Date: 20<sup>th</sup> April 2020  
Our ref: CPD: 12172020  
Your ref: 6/2020/0781/MAJ  
Direct No: 01707 355225  
E-mail: [gerry.brophy@herts.pnn.police](mailto:gerry.brophy@herts.pnn.police).

**Re: Accord House 28 Bridge Road East**

Thank you for sight of this additional housing application at this site, on which I comment from a crime prevention and safety aspect only.

FIRST FLOOR; FORMER OFFICE ACCOMMODATION, TO BE CONVERTED TO RESIDENTIAL USE IN RELATION TO SEPARATE PRIOR APPROVAL PROCESS

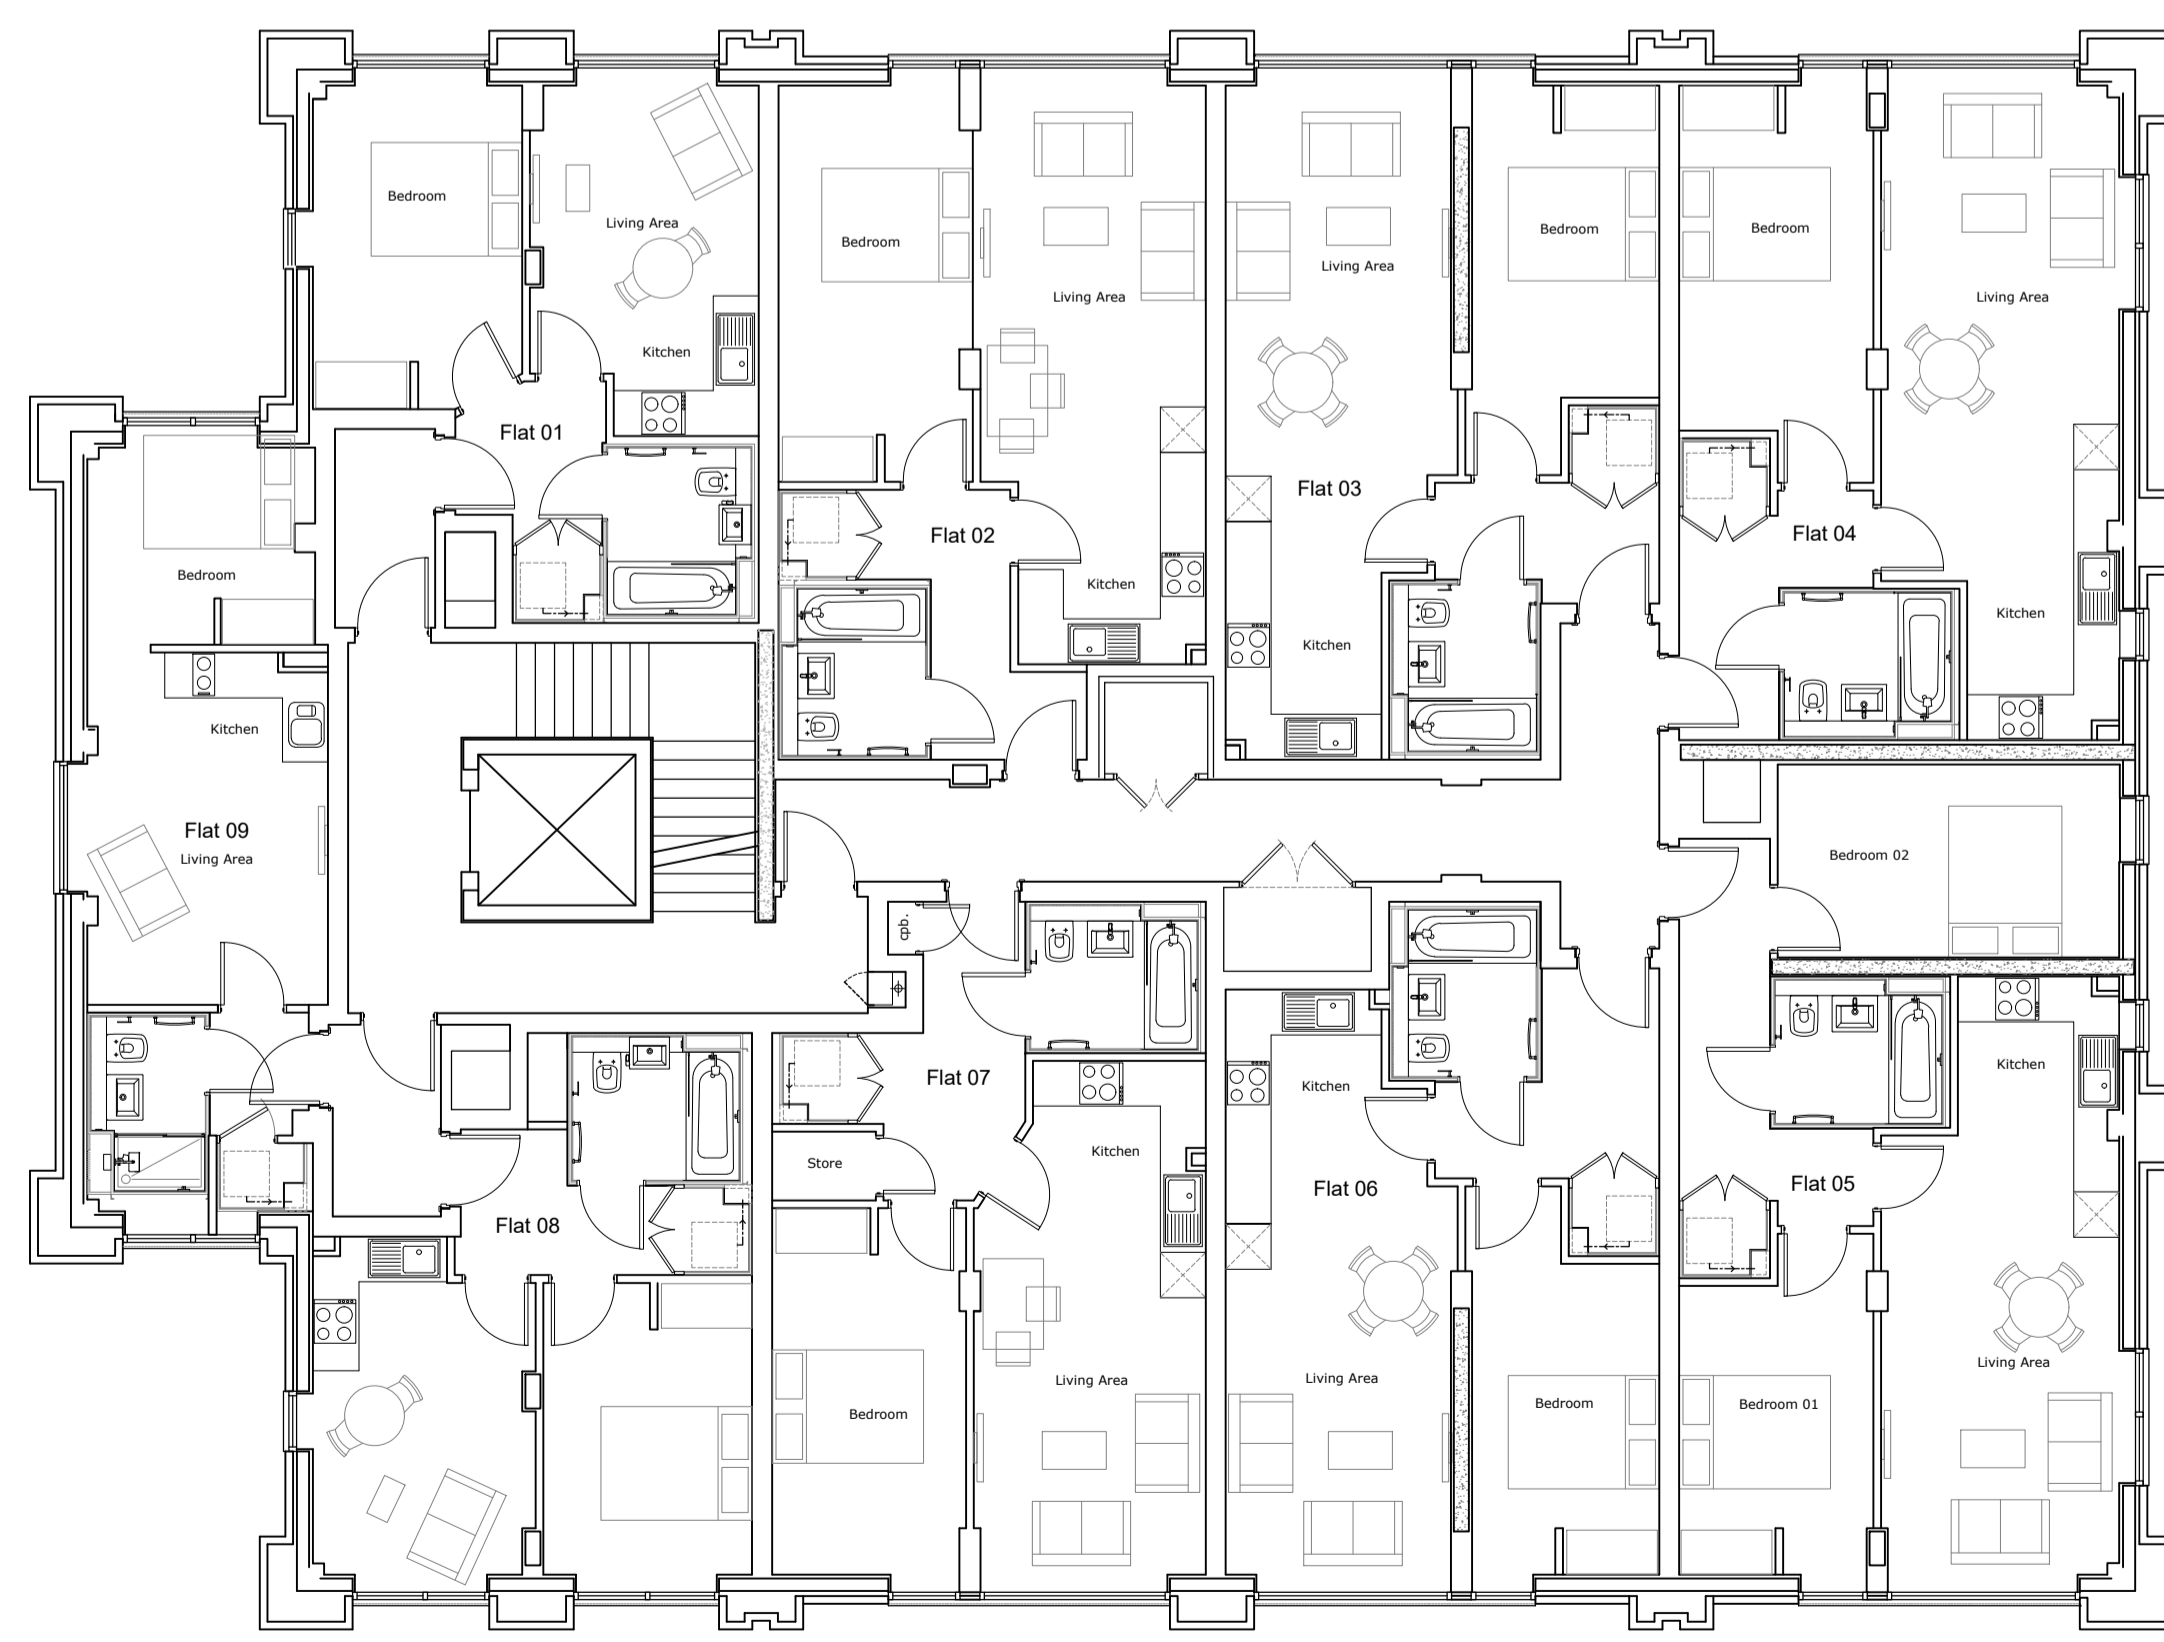
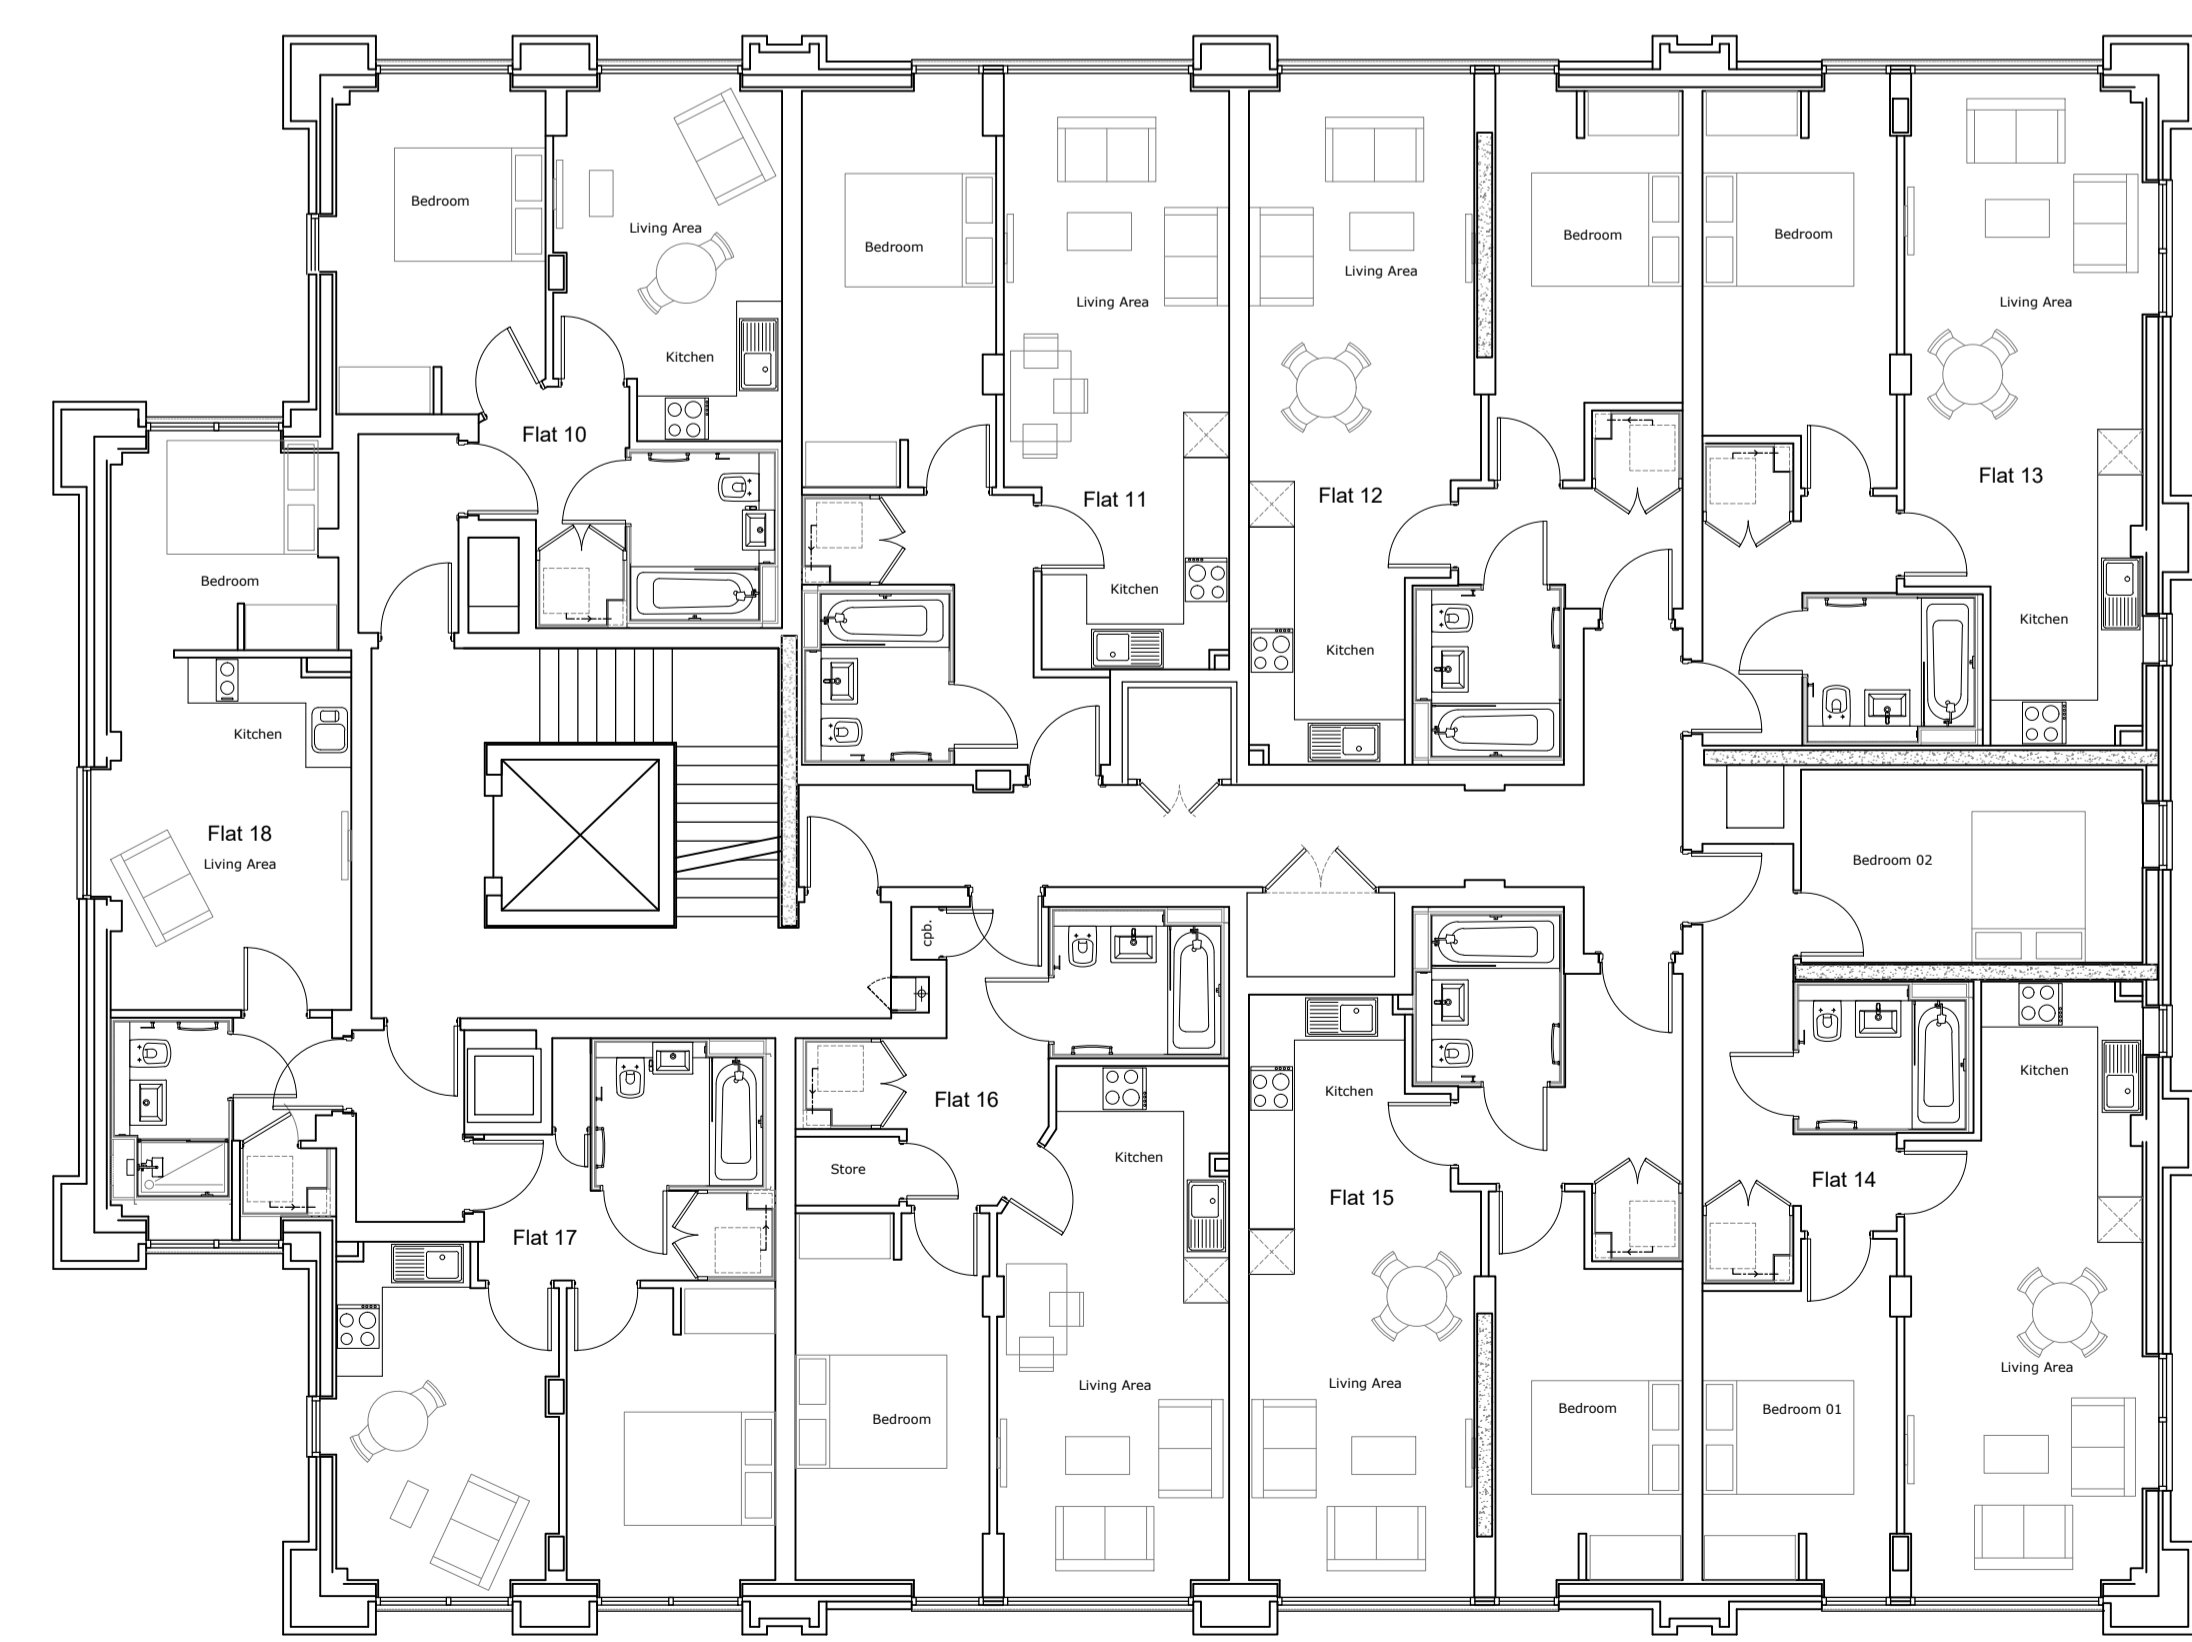
I am concerned with the intention to remove the second stairwell. In the event of a fire in or near the ground floor stairwell, there is no other safe escape route for residents above ground level. I would like to see a second means of escape from this medium height building.

Audio visual access control must be fitted to the main entrance door. Either the lift must have access control to each floor or the door leading to an average of seven (7) flats on each floor must have a fob type access control system in place.

The large wall that abuts Mercury House will have no windows to prevent overlooking. This also prevents natural surveillance and can allow criminal activity to flourish in the resultant narrow triangular piece of land that serves little purpose or use and will need to be enclosed to prevent abuse.
